Our Ref: BN/18/22/DOC

Approval of details reserved by condition imposed under ref BN/17/21/PL relating to Condition Nos 3 - materials and finishes, 5 - Construction Management Plan, 9 - Energy Statement, 13 - surface water drainage, 14 - foul water disposal, 15 - Biodiversity Enhancement Plan.

The Cottage Highground Lane Barnham PO22 0BT

Arun District Council have decided to **REFUSE details reserved by condition for the following reasons:**

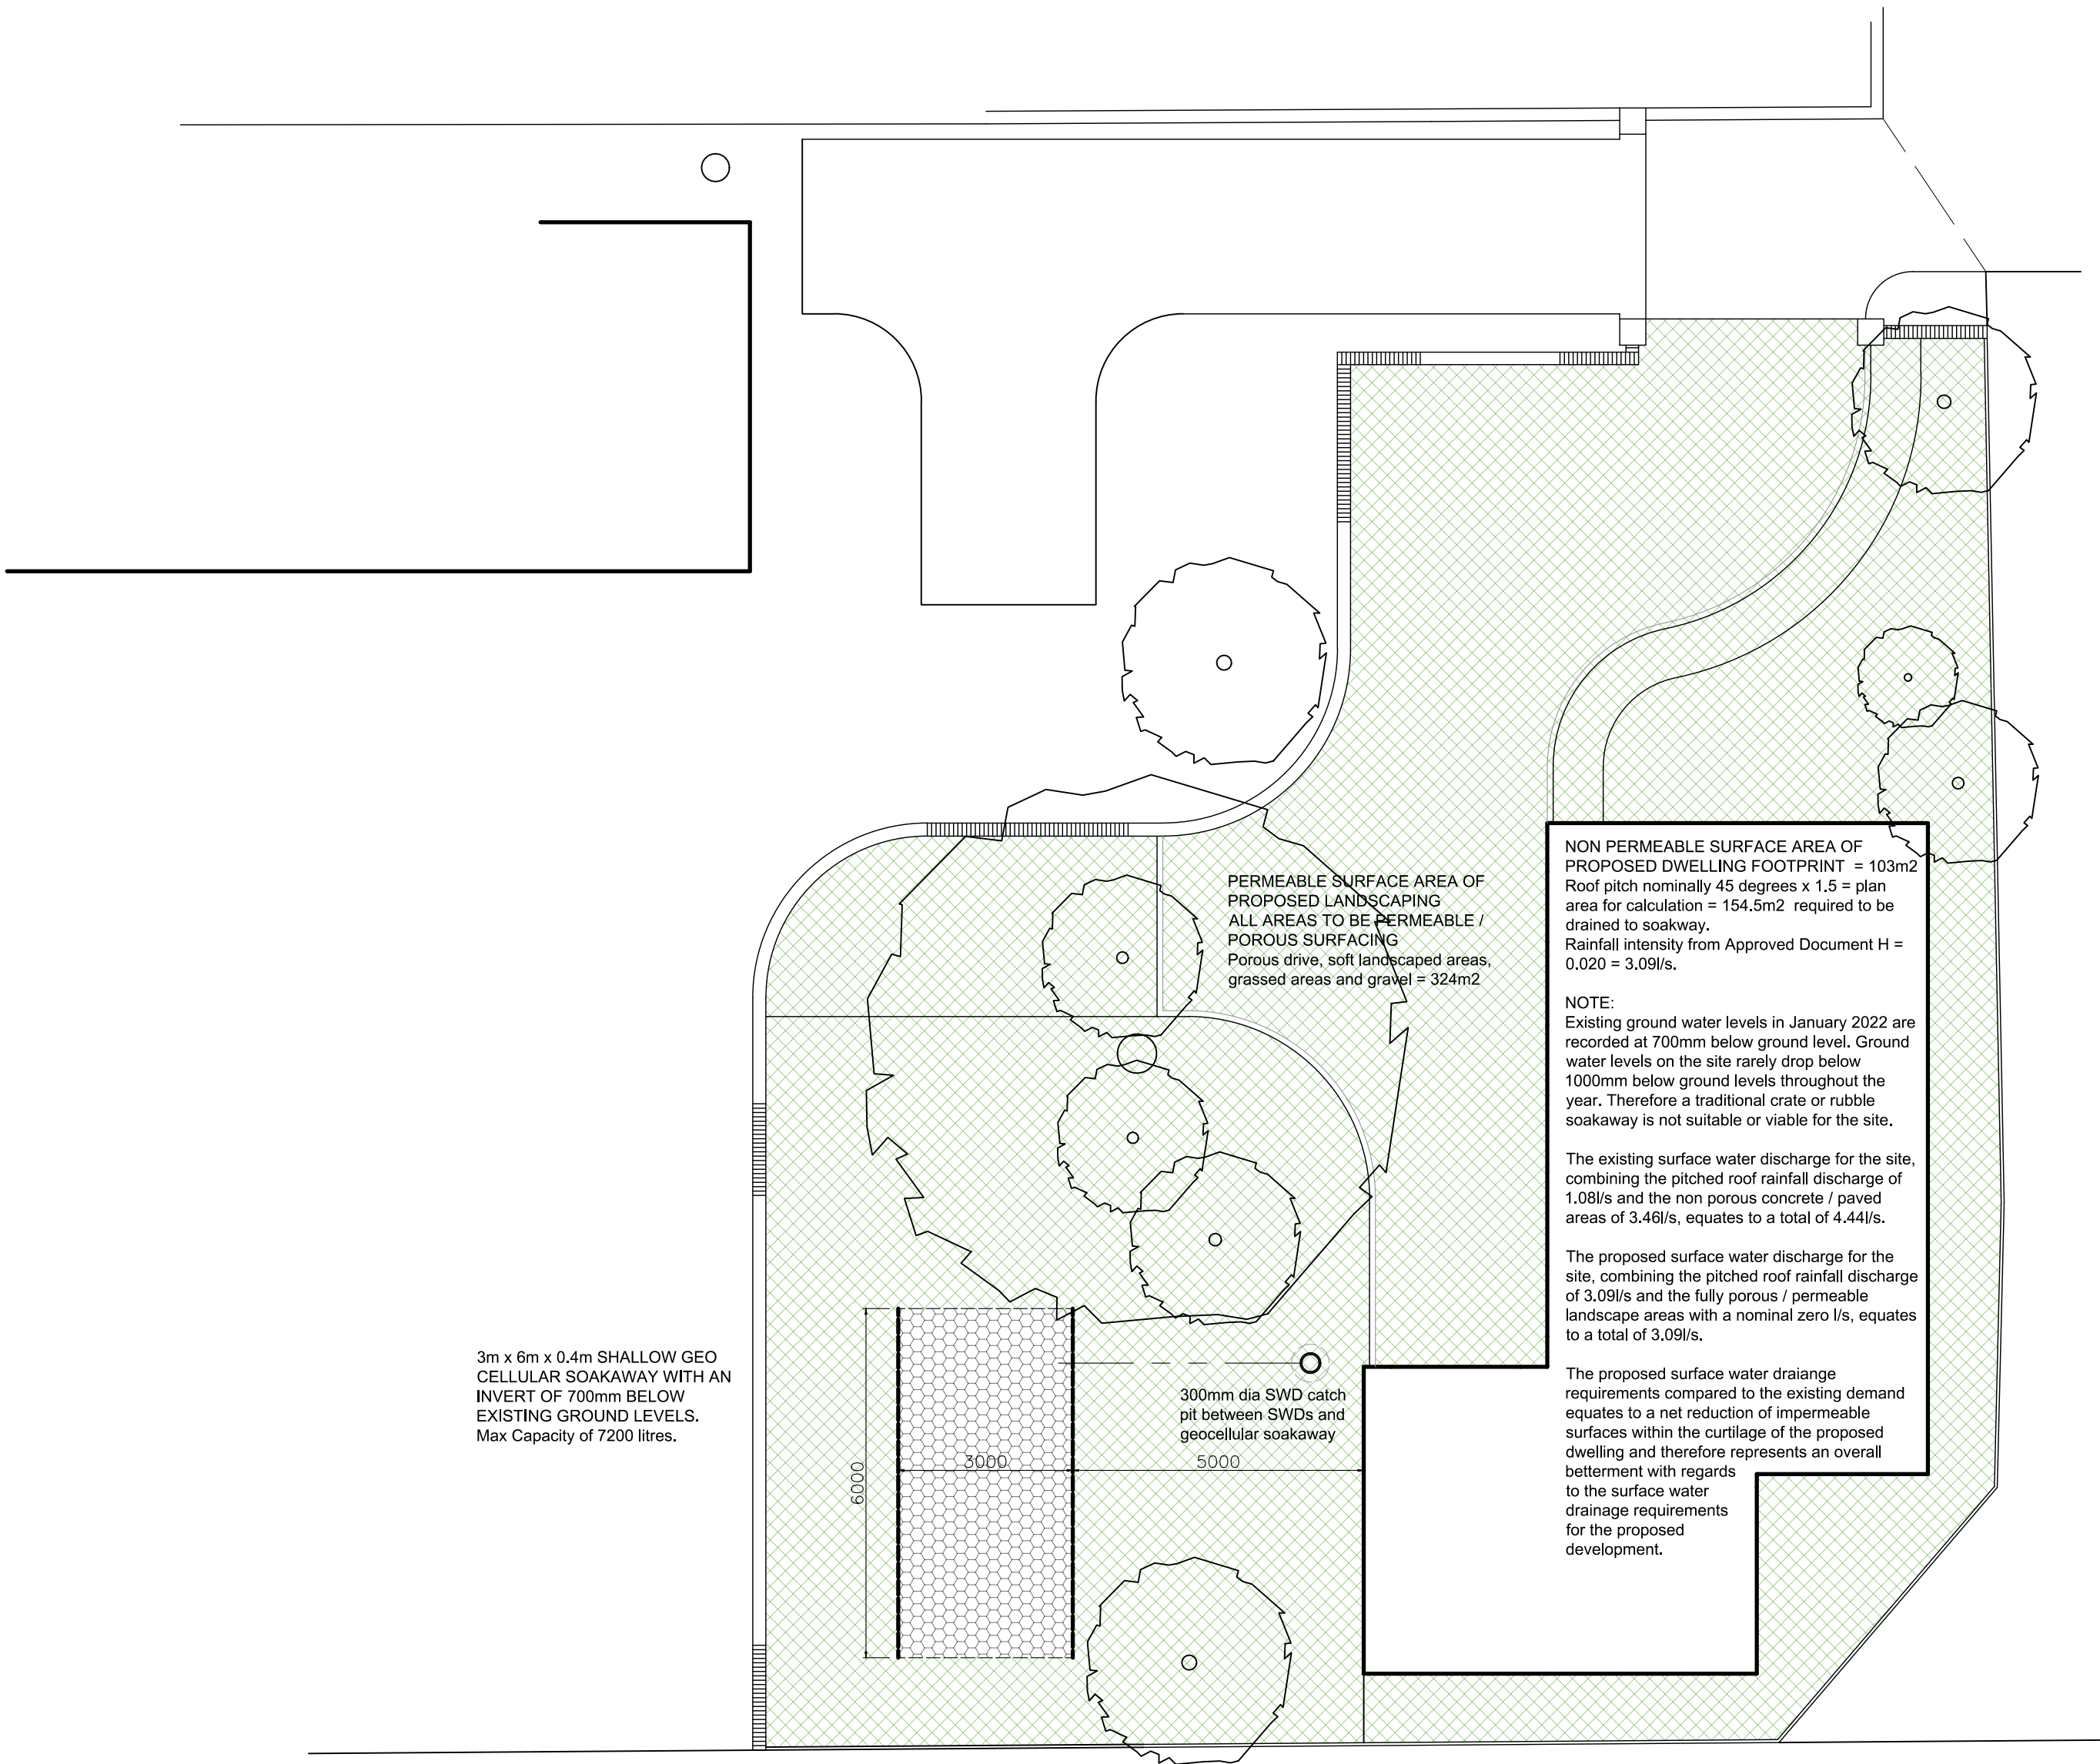
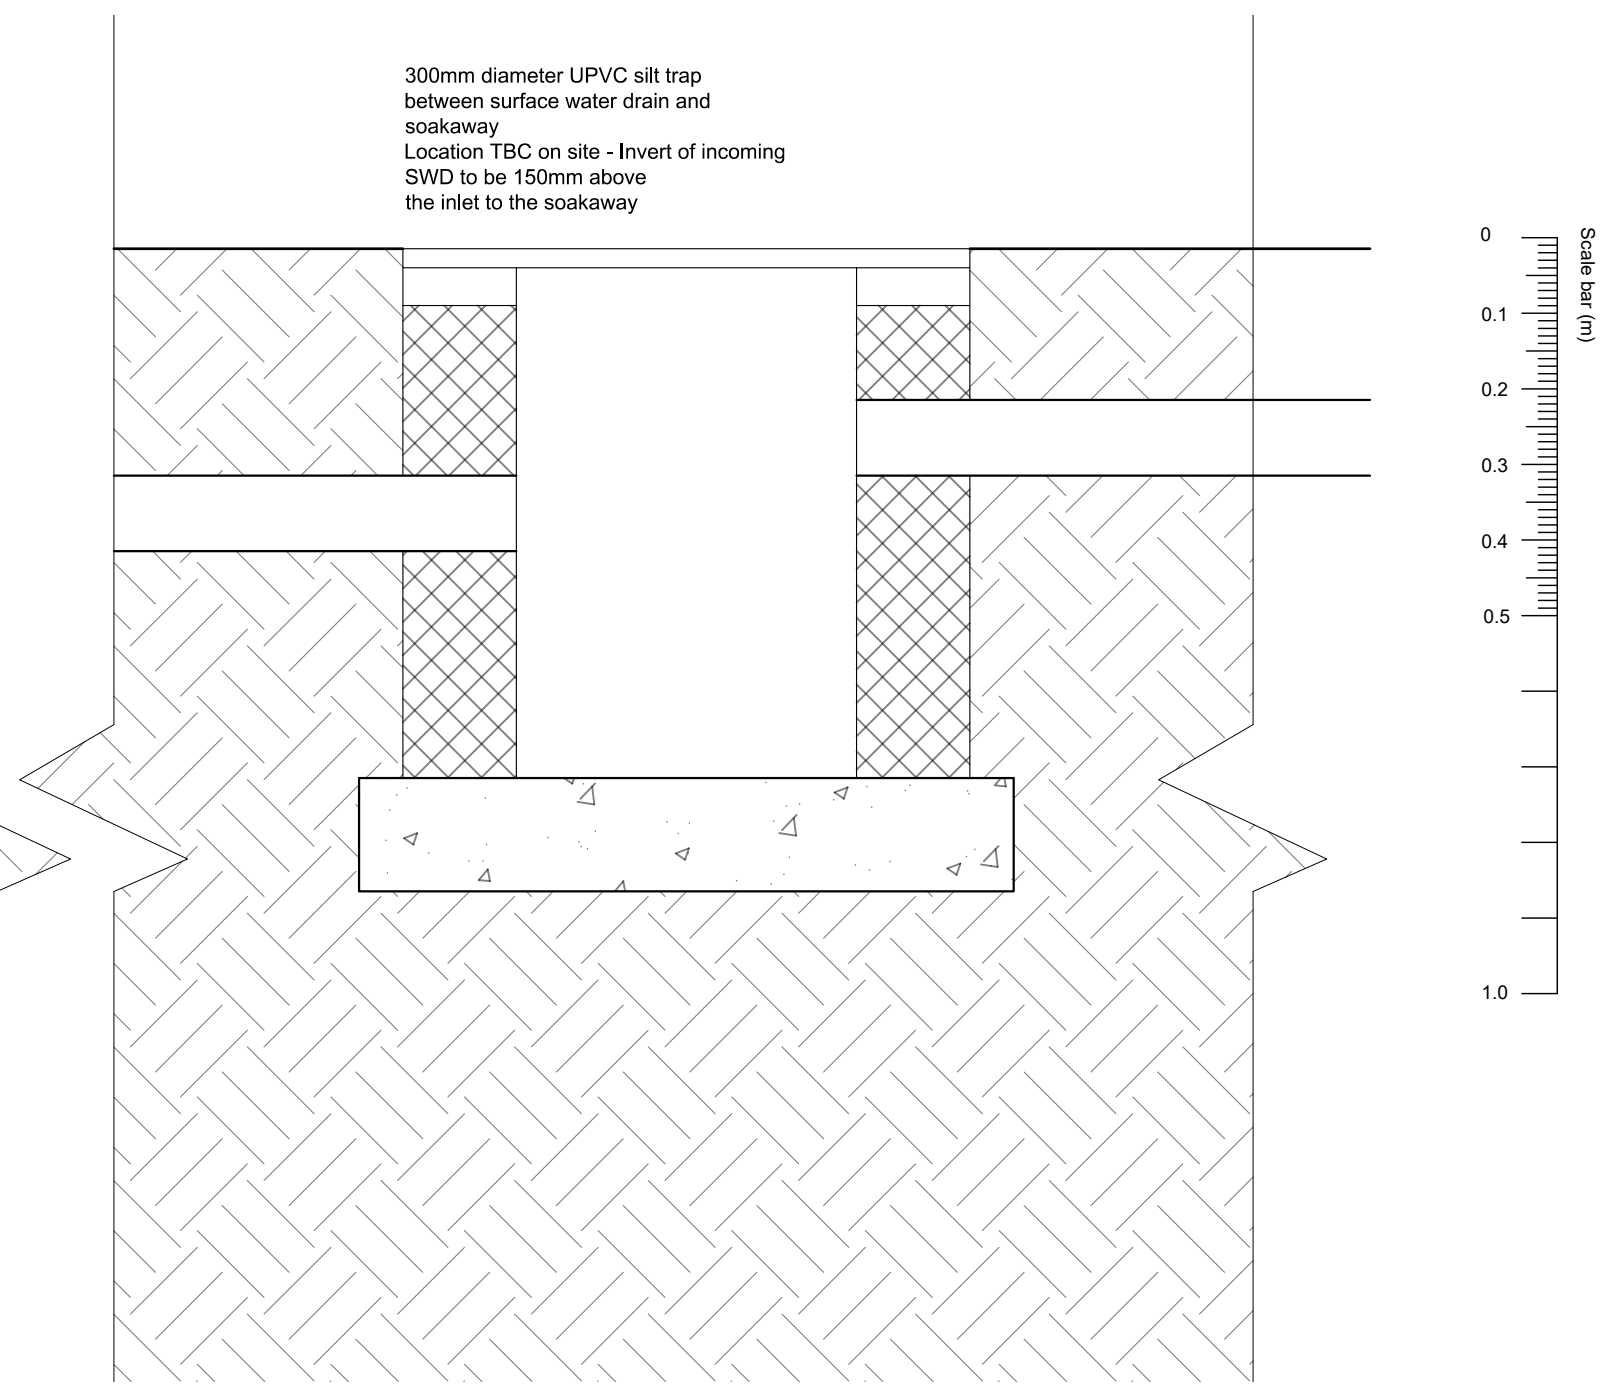
No formal winter groundwater monitoring has been undertaken or agreed. There are observations of groundwater which will prove to be useful.

Likewise, no winter infiltration testing has been completed. The applicant attempts to justify the lack of formal site investigations in the statement, however, both winter groundwater monitoring and winter infiltration testing are a stipulation of the Condition that they wish to discharge. These are not optional requirements.

1. Please specify the type of crate to be used - this must be suitable for vehicular loading at shallow depth.
2. Pipes labelled with pipe materials - or a note to state pipe materials if the same for all.
3. All inspection chambers to be labelled with a reference number, cover level, invert level and cover loading grade.
4. Add an inspection chamber to remove the pipe bend on the north side of the property.
5. Label catch-pits/silt traps with sump depths.
6. Provide construction detail drawing of pipe bed and surround, for shallow depths pipes are expected to be encased in concrete.
7. Provide construction detail drawing for inspection chambers.
8. Amend soakaway construction detail drawing to include vent location(s) and note invert level of incoming pipe. This should be above the level for the 1 in 10 year +40% event.
9. Provide a construction detail drawing for your permeable paving.
